Your Ref: OWPC26283
Our Ref: AW/66/20/HH 10-03-2020
Please ask for:
Amber Willard

Addition of first floor to convert bungalow to house.
41 Gossamer Lane Aldwick

Thank you for your internet representation made on 5th April 2020 which has been recorded as '**an objection**' with the comments as follows:

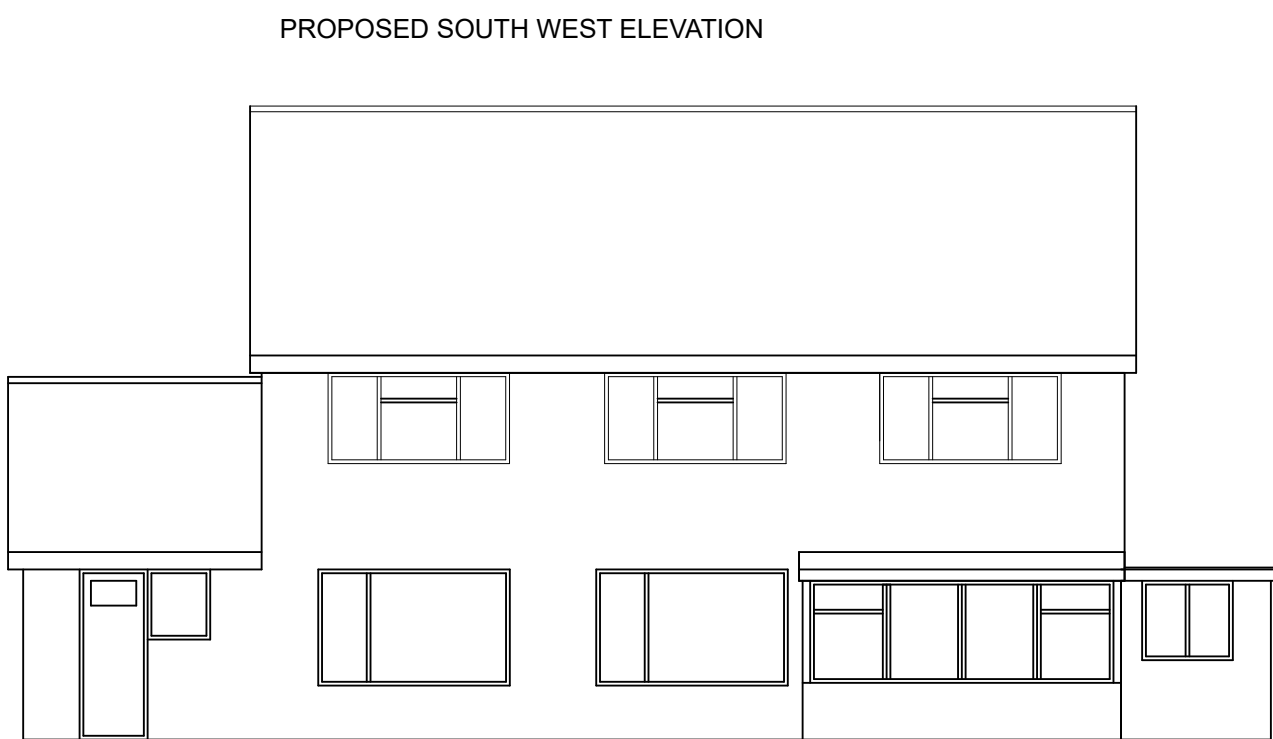
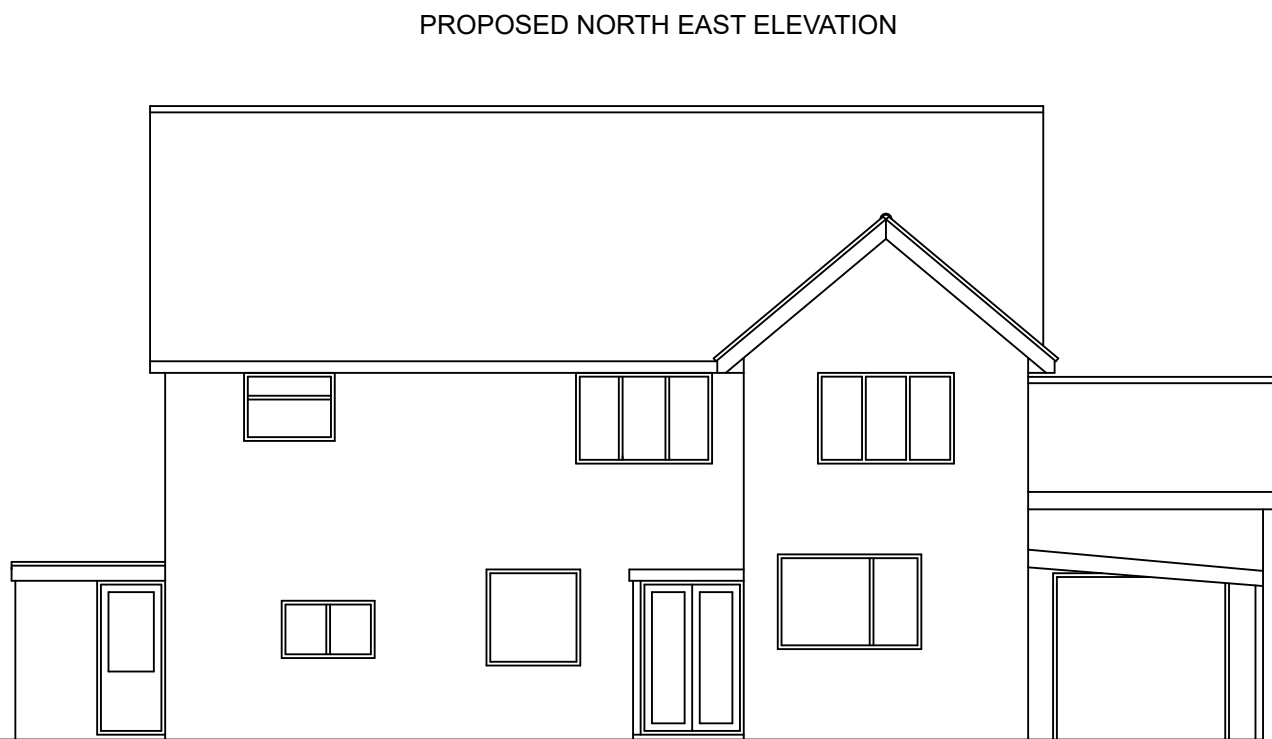
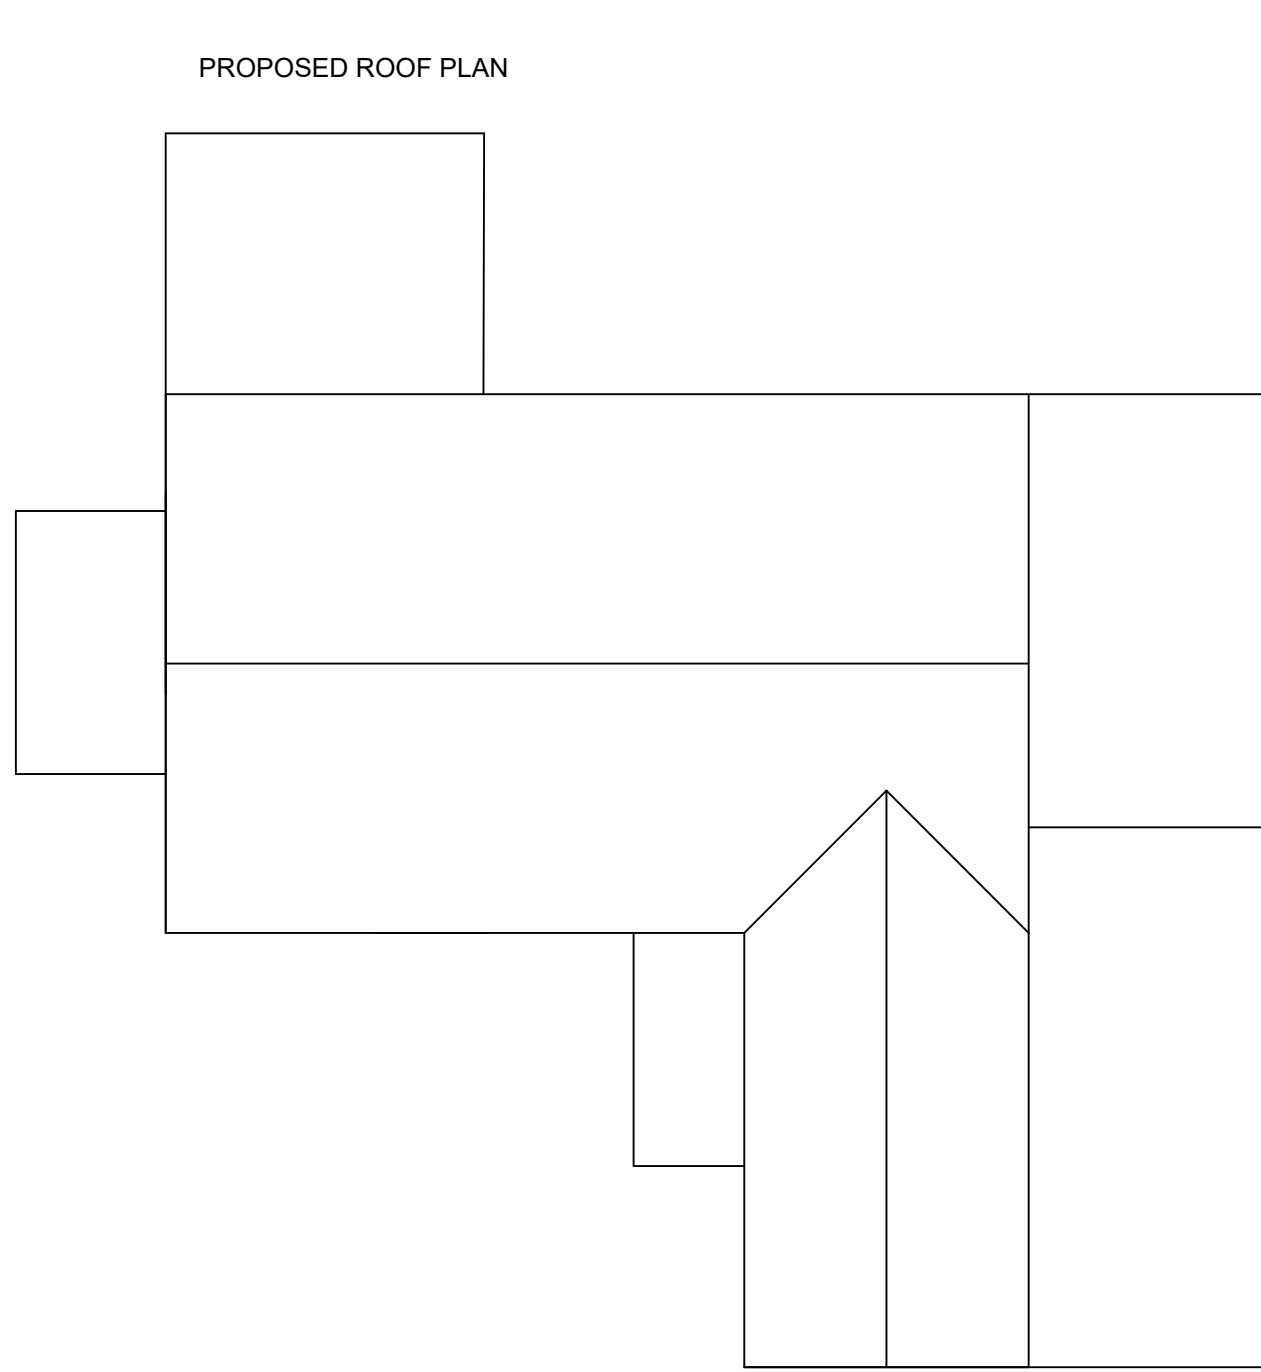
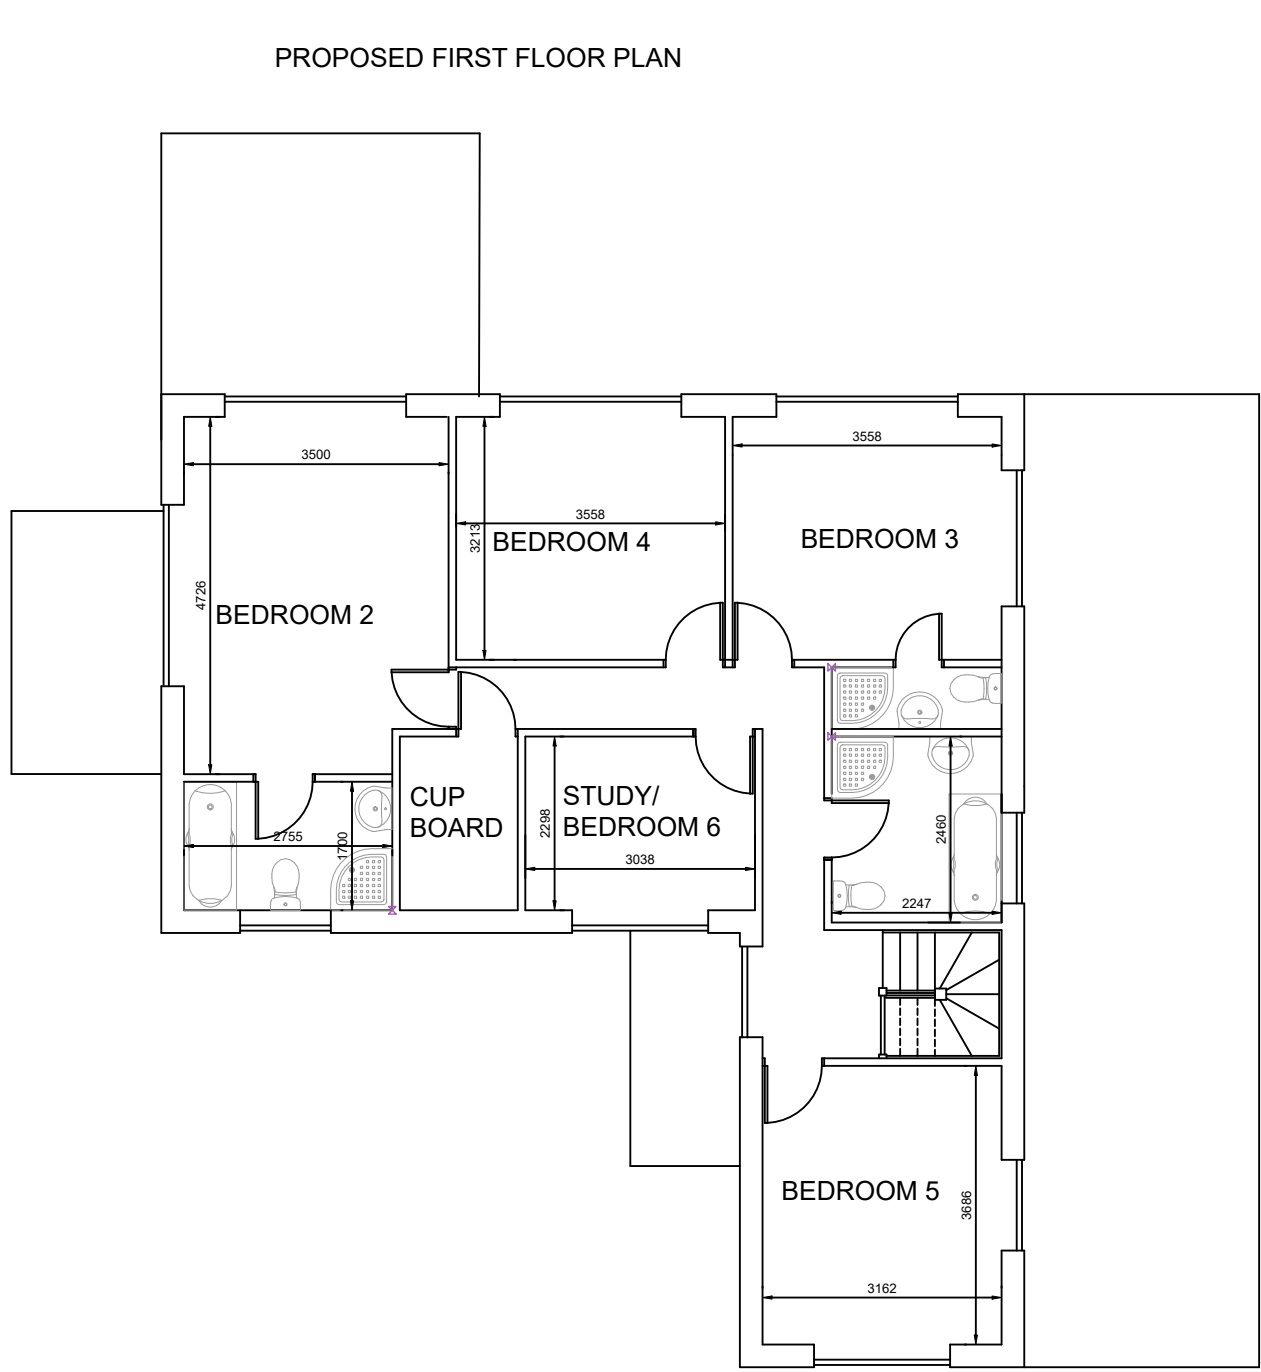
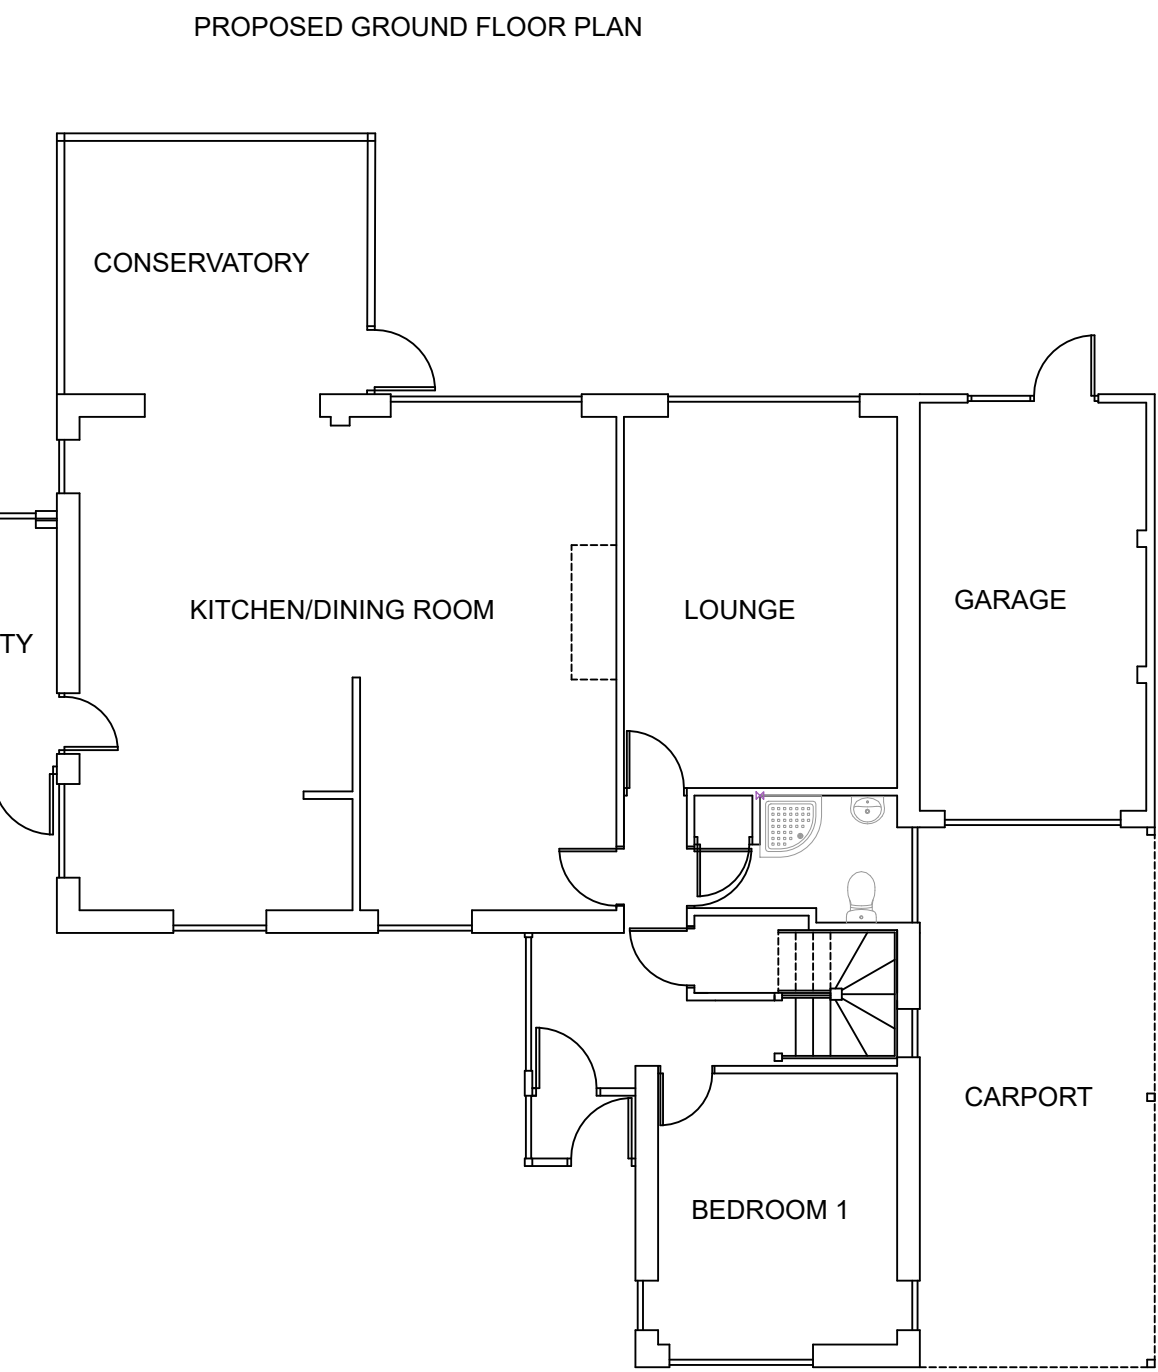
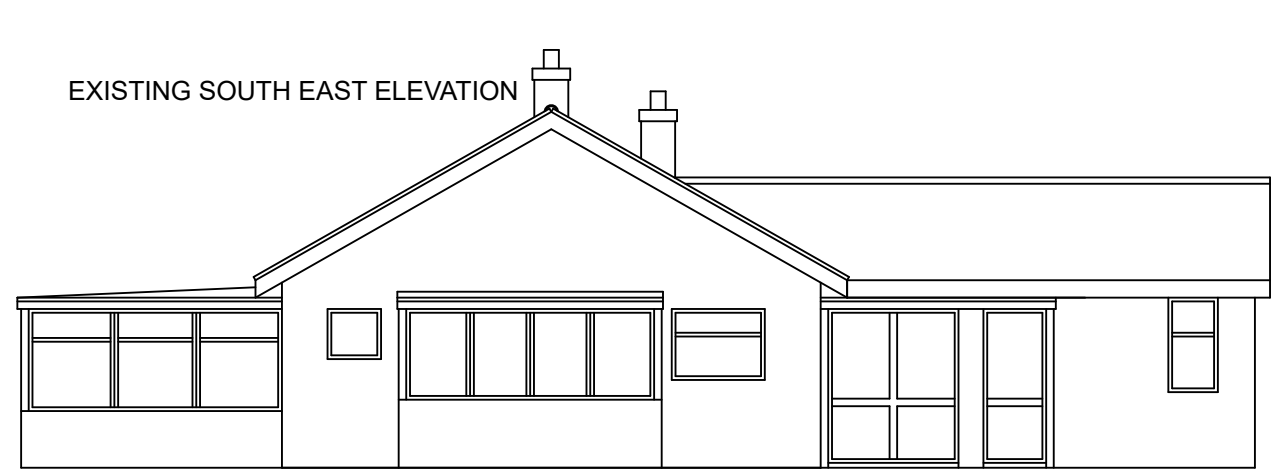
The proposed first floor extension would include an additional 11 windows, 4 of which would overlook the rear of our property. The two windows in proposed bedroom 2 would cause the most significant reduction of our privacy.

The proposed window on the South East elevation would be approximately 6 metres away from our window and would look directly into our bedroom.

The proposed bedroom 2 has a second window on the South West elevation approximately 7 metres away from our property which whilst not ideal would be acceptable.
